Transport
for NSW

**State Significant Development – Norwest Private Hospital Expansion,
11 Norbrik Drive, Bella Vista (SSD 13_6074) Notice of Exhibition**

Thank you for your letter dated 6 December 2013 requesting Transport for NSW review and comment on the above State Significant Development.

STAGE 7
Basement Floor
6 car spots lost

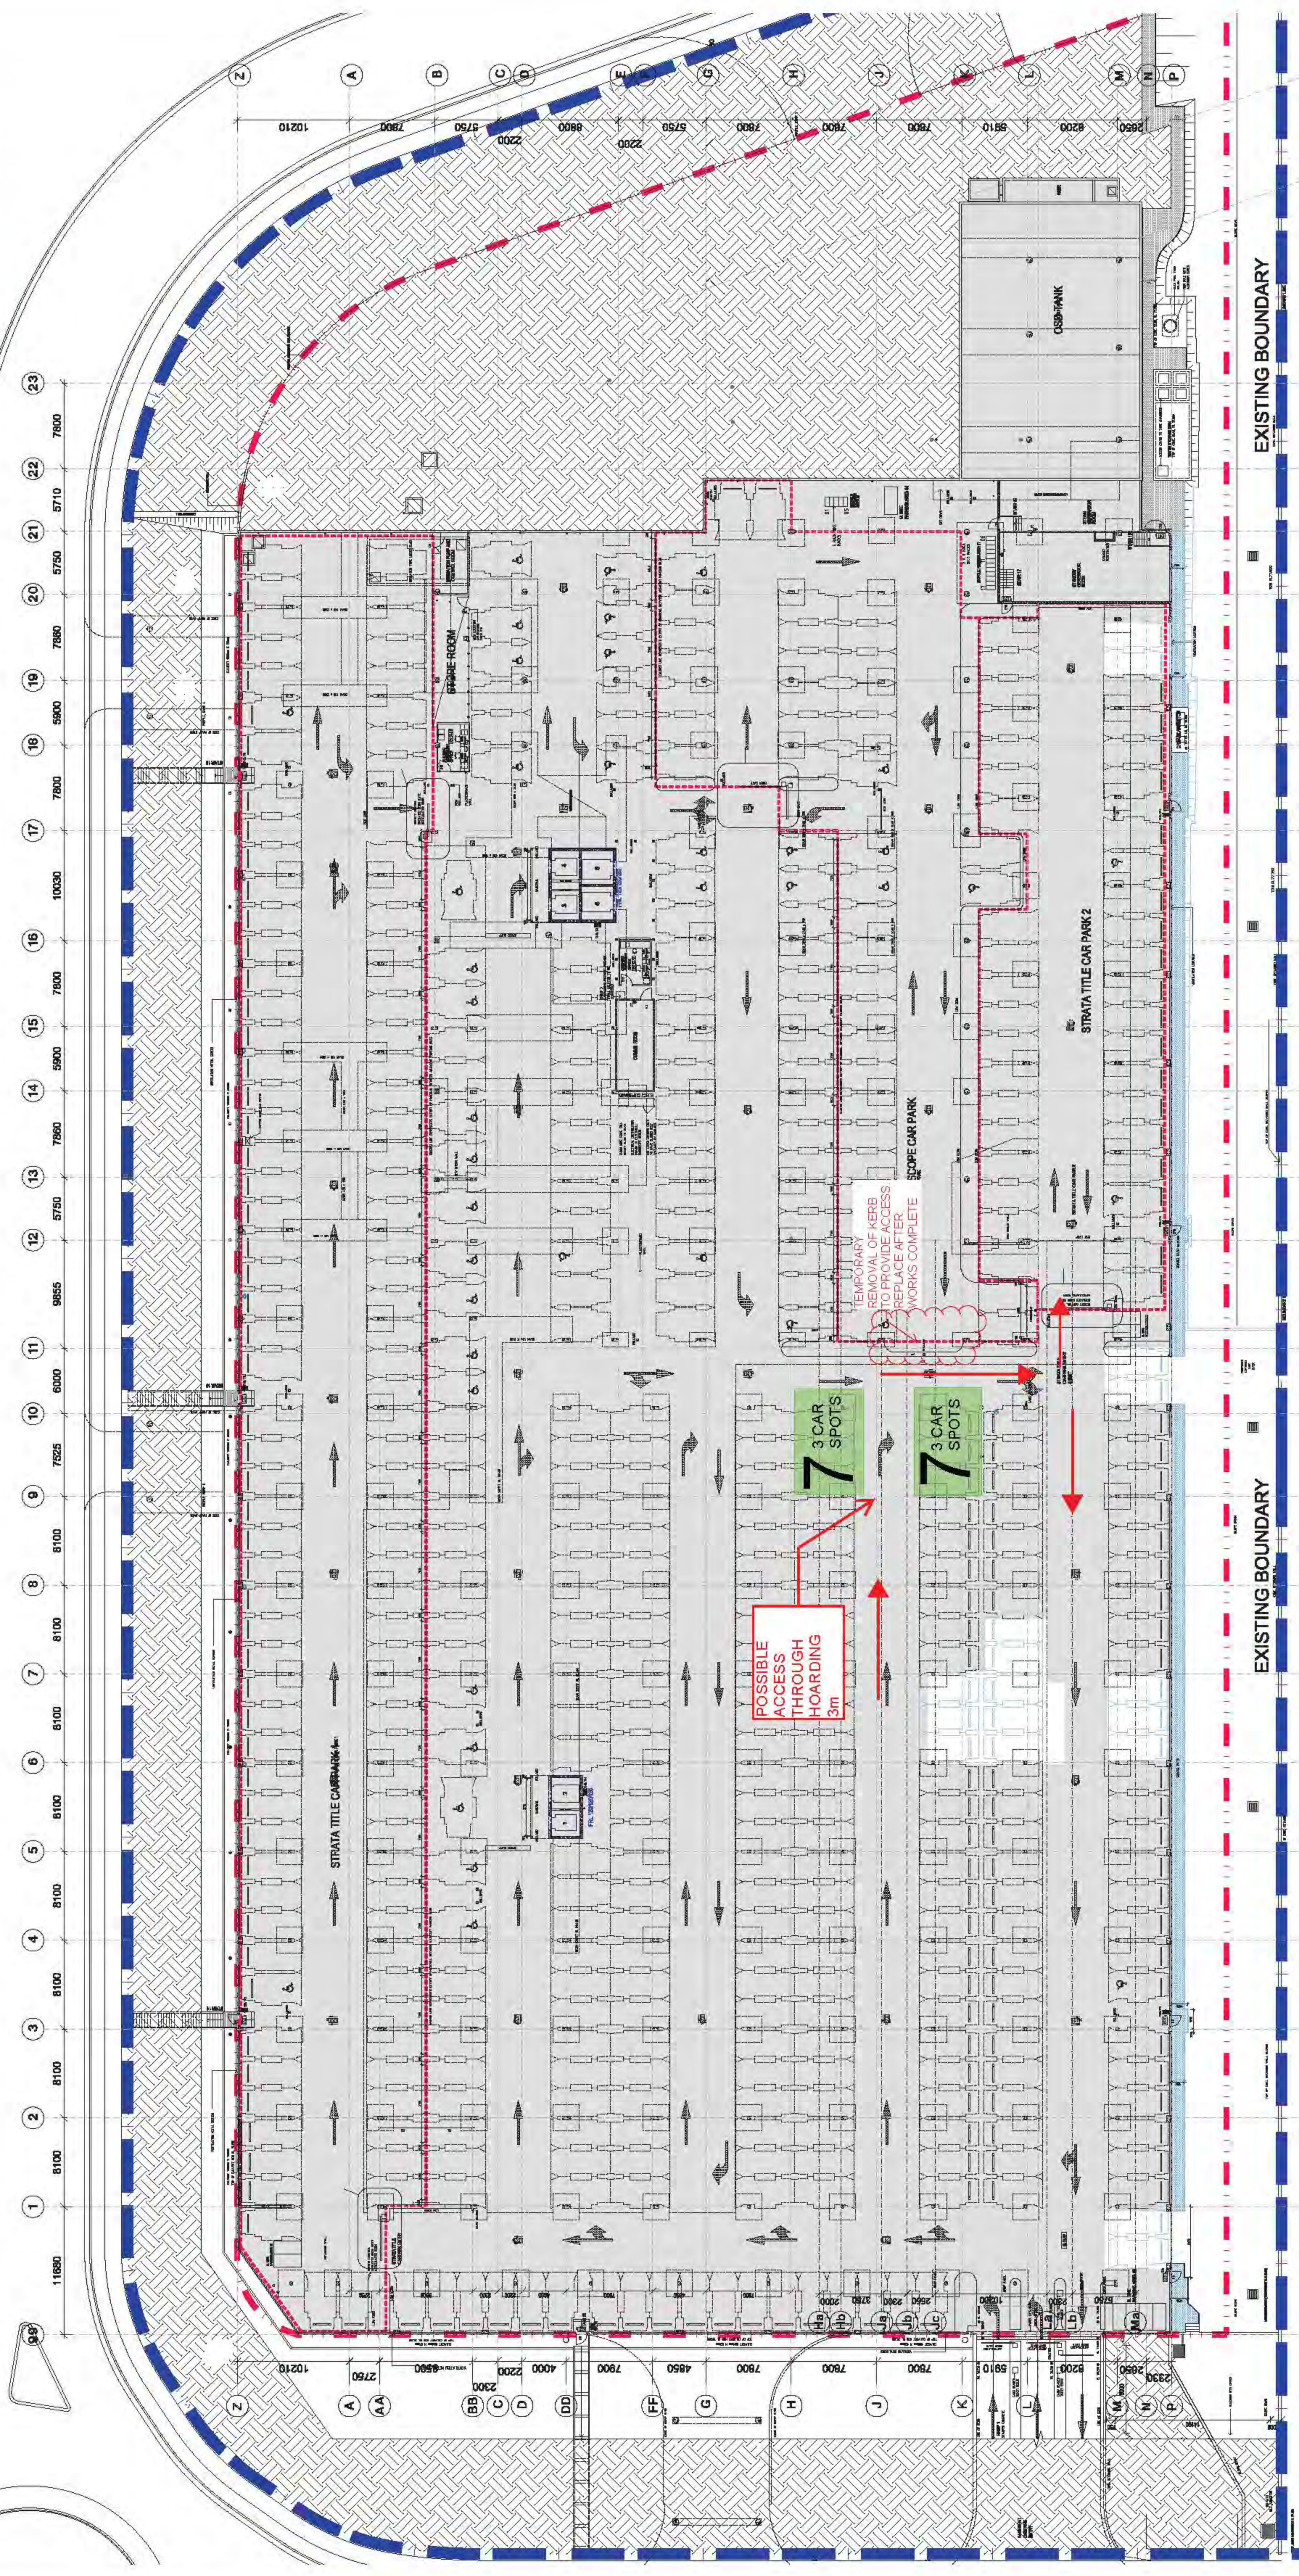
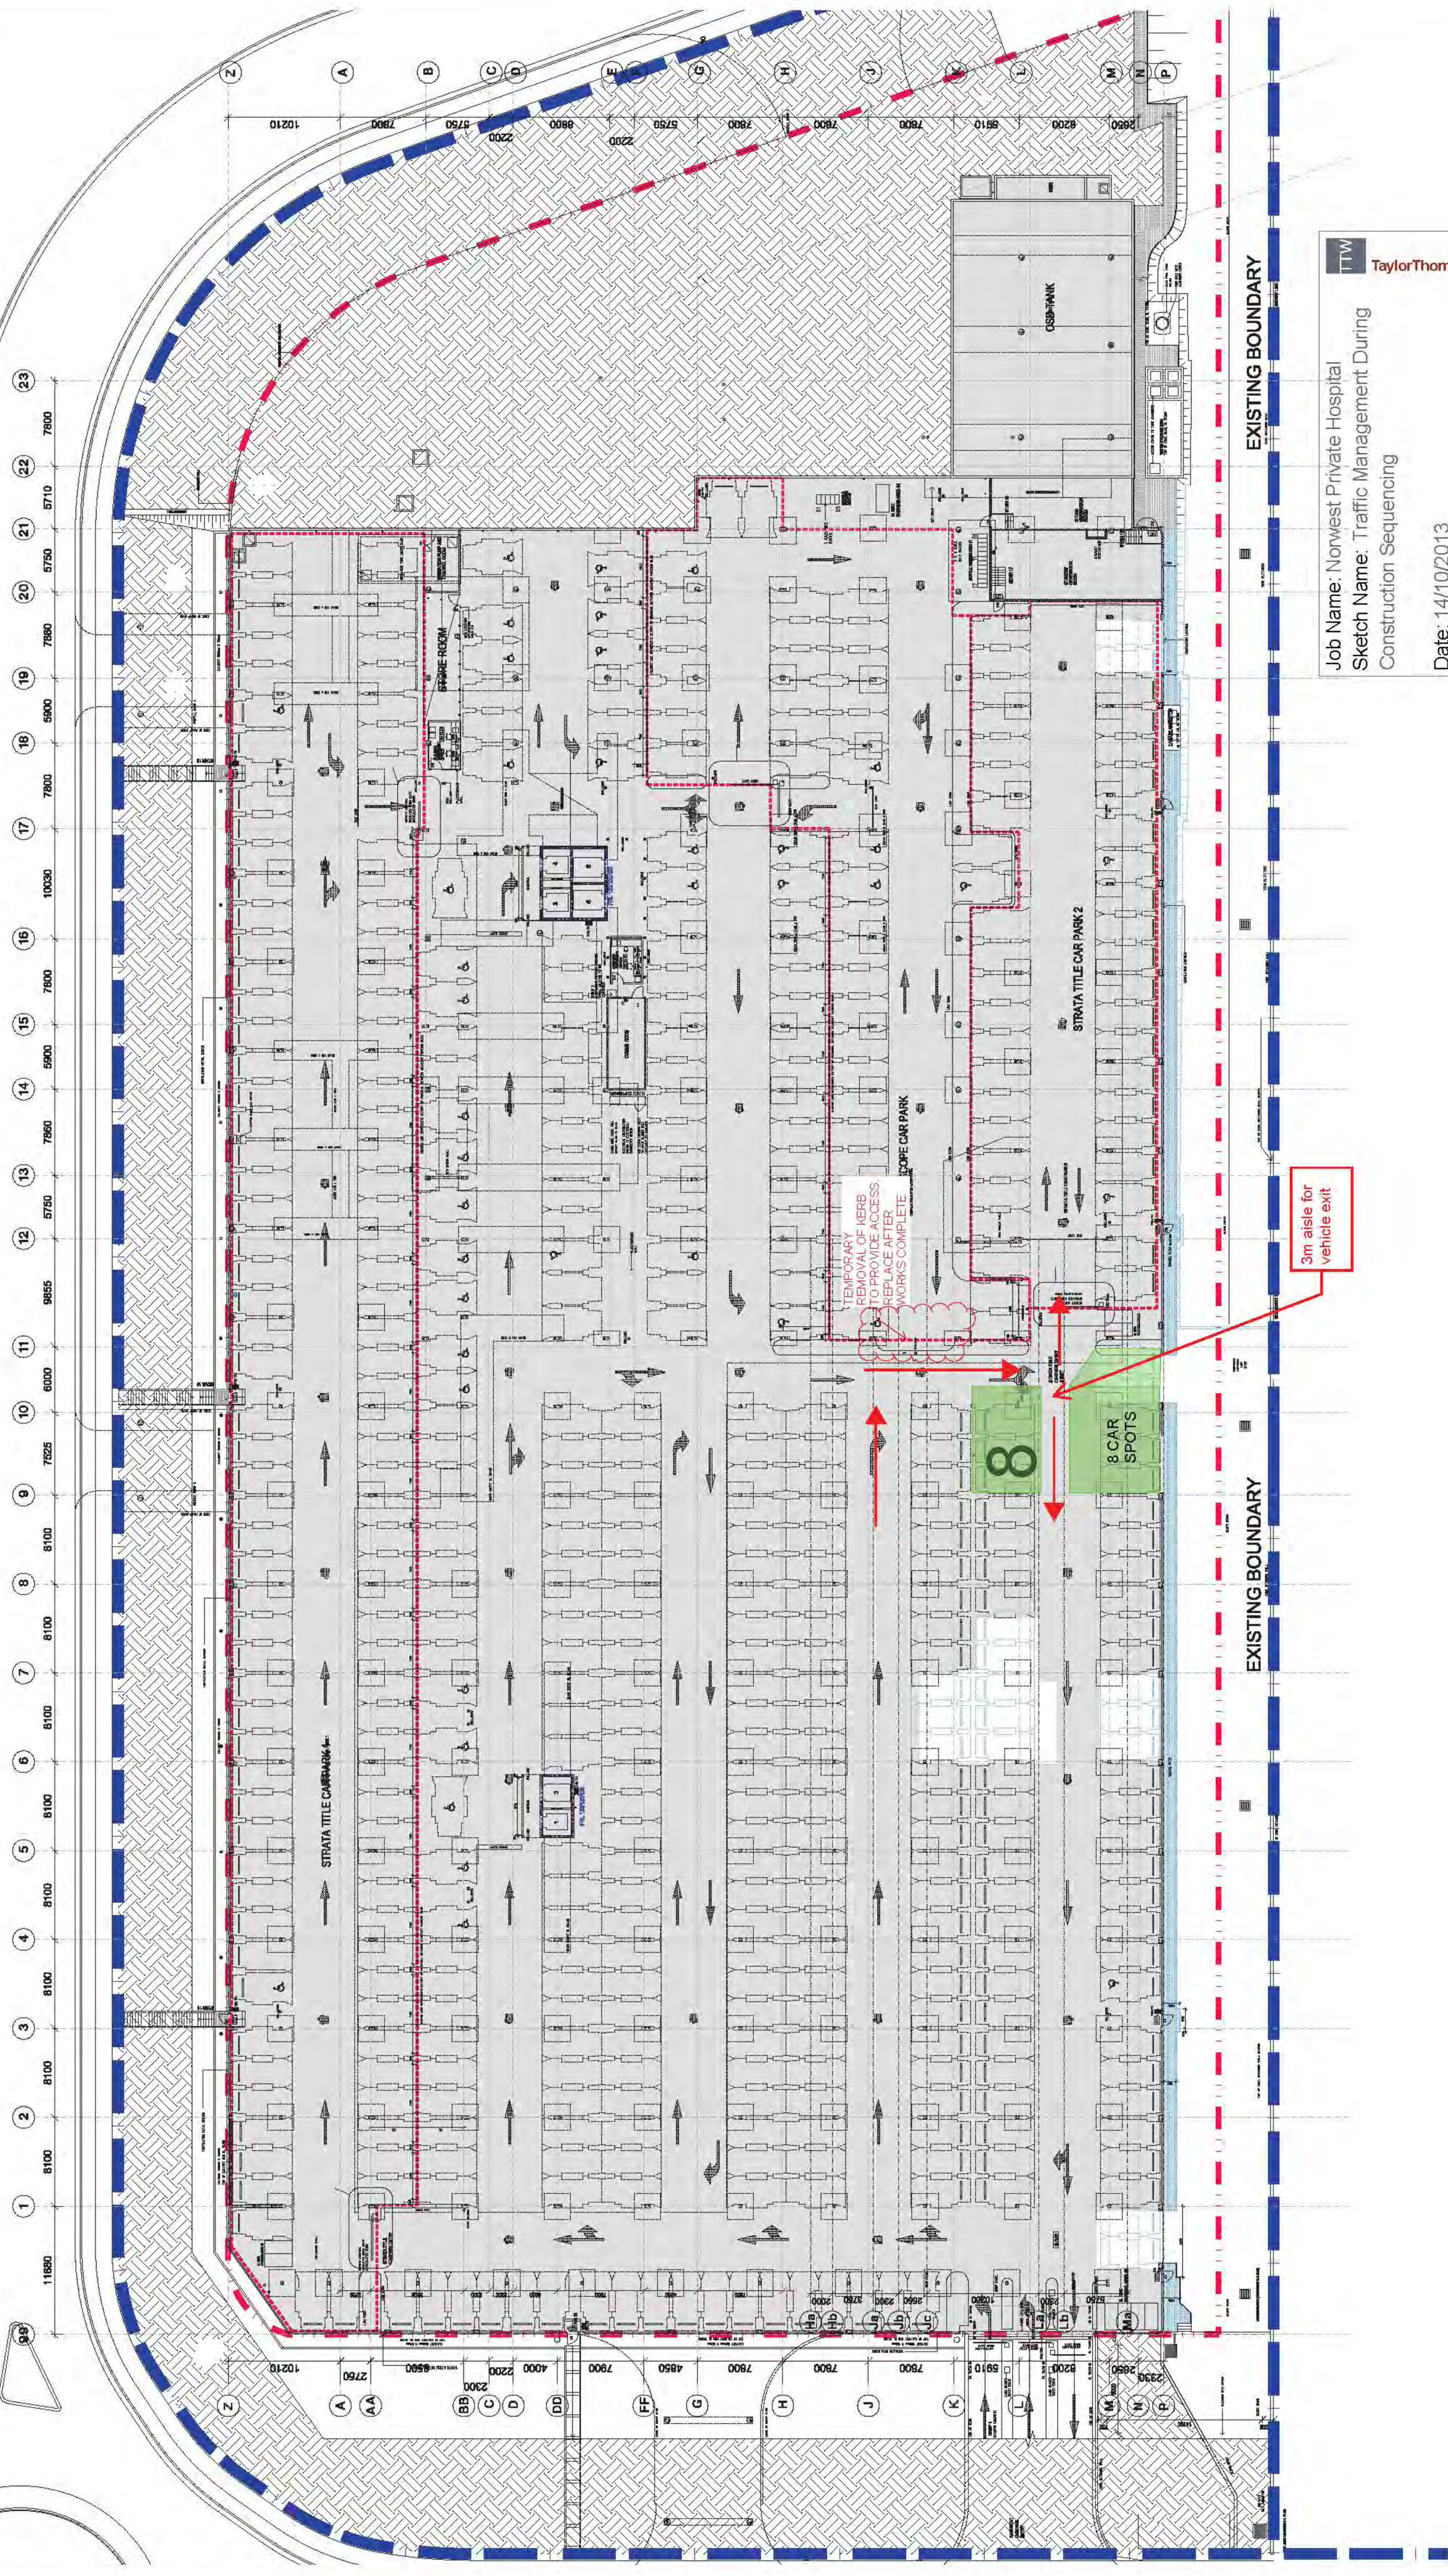
- Conditions of development consent should include the need to prepare a Traffic Management Plan for Construction Activities (TMP), which should detail construction vehicle routes, number of trucks, hours of operation, access arrangements and traffic control measures to undertaken during the construction phase of the project. The TMP should be submitted for review and approval prior to commencement of any works on site.

- The TMP does not provide information on the potential construction traffic impacts to bus services operating within the vicinity of the site. Transport for NSW considers that it is likely there would be impacts to bus services as the proposed construction vehicles route around the hospital site is the same as that for bus services. Transport for NSW recommends that any development approval include a condition that the construction of the hospital expansion be undertaken in a manner that does not create any safety concerns and minimises disruption for bus services.
